Current Zoning: N1-A and R-8MF(CD)
Proposed Zoning: R-8MF(CD) and R-8MF(CD) SPA

Approximately 21.12 acres located along the southeast side of Mallard Creek Road, west of Penninger Circle, and north of Morris Estate Drive.

The petition proposes to rezone one parcel to add an additional 4 townhome buildings for a total of 20 additional townhome units to the project and 116 units total for the site. This rezoning plan was previously approved under rezoning petition 2020-099.

Staff recommends approval of this petition upon resolution of outstanding issues related to transportation.

Rezoning Plan
Petition # 2022-205

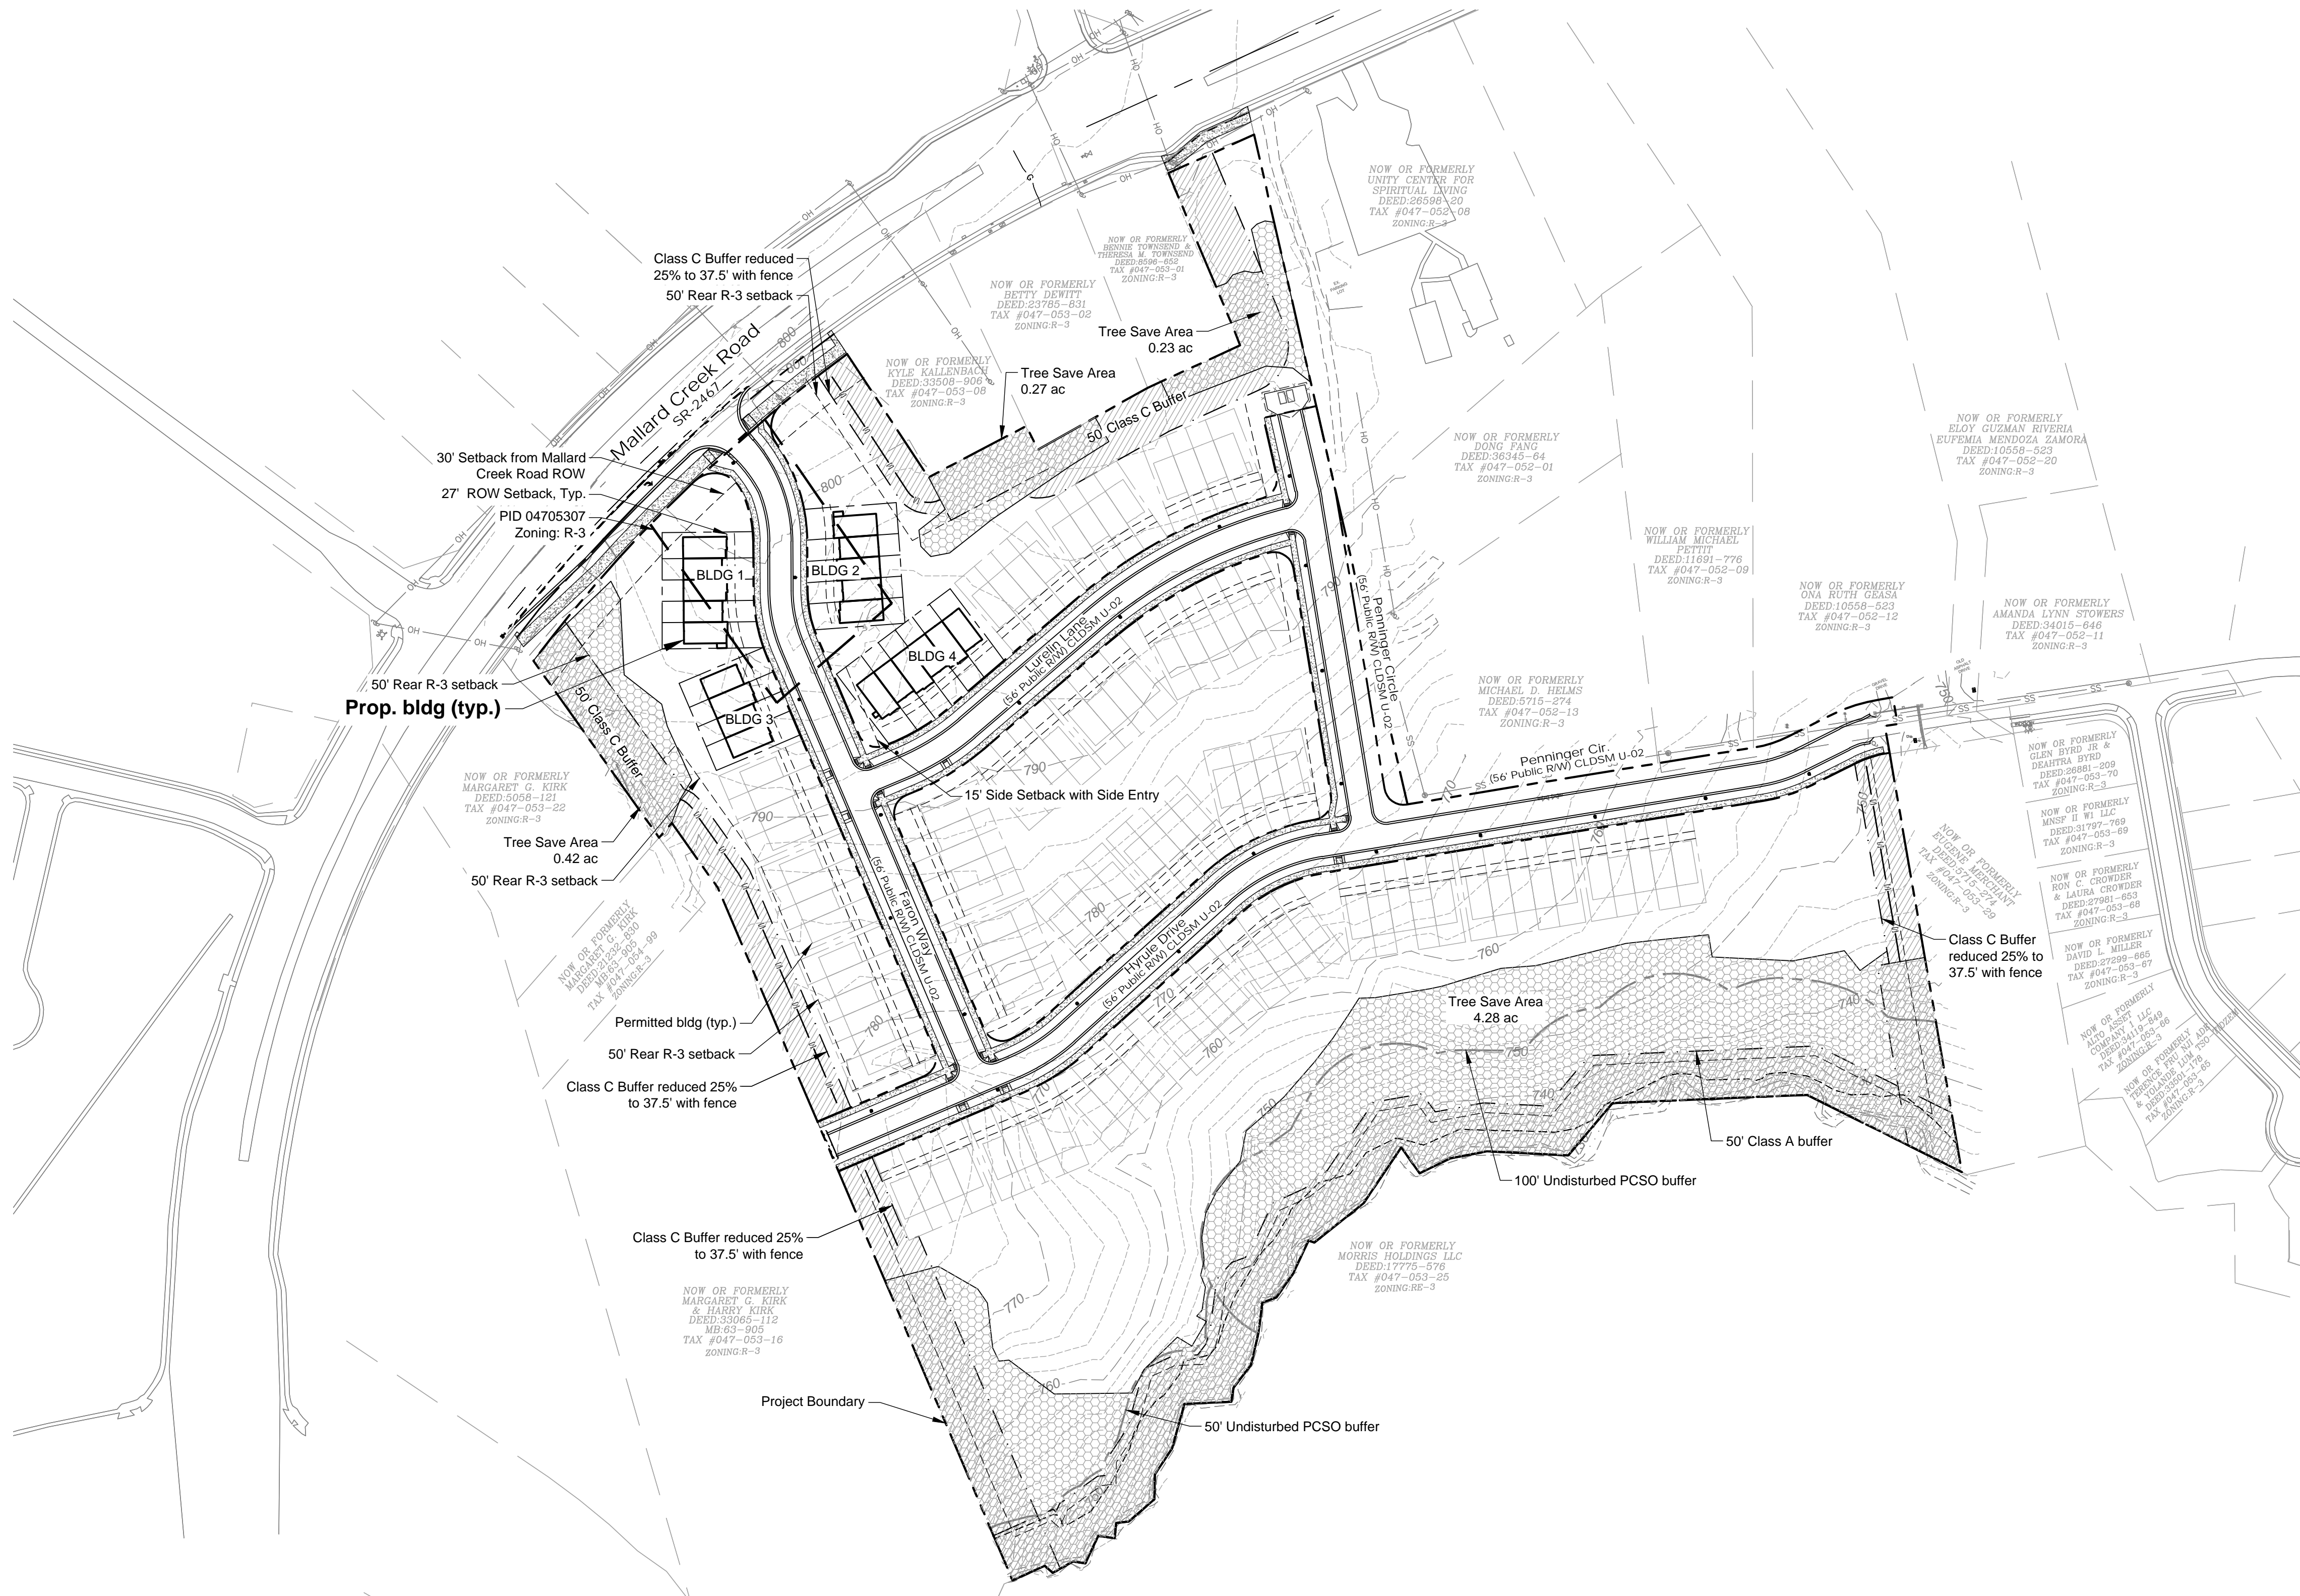
1. Label and dimension the curb and gutter from the centerline for each road on the site plan.
2. Revise site plan and conditional note(s) to commit to dedicate 50-feet of right-of-way from the road centerline. The site plan shall label and dimension the right-of-way from the road centerline.

3. Add a conditional note specifying "A Right-of-Way Encroachment Agreement is required for the installation of any non-standard item(s) (irrigation systems, decorative concrete pavement, brick pavers, etc.) within a proposed/existing City-maintained street right-of-way by a private individual, group, business, or homeowner's/business association. An encroachment agreement must be approved by CDOT prior to construction/installation. Contact CDOT for additional information concerning cost, submittal, and liability insurance coverage requirements."

4. Add a conditional note specifying "The petitioner needs to complete and submit the Right of way Abandonment Petition form to CDOT for review. The Right of Way Abandonment process is controlled by North Carolina General Statutes and is independent of this rezoning process."

5. Add conditional note specifying "All public roadway improvements will be subject to the standards and criteria of CDOT and NCDOT, as applicable, to the roadway improvements within their respective road system authority. It is understood that such improvements may be undertaken by the Petitioner on its own or in conjunction with other development or roadway projects taking place within the broad northeastern Mecklenburg area, by way of a private/public partnership effort or other public sector project support."
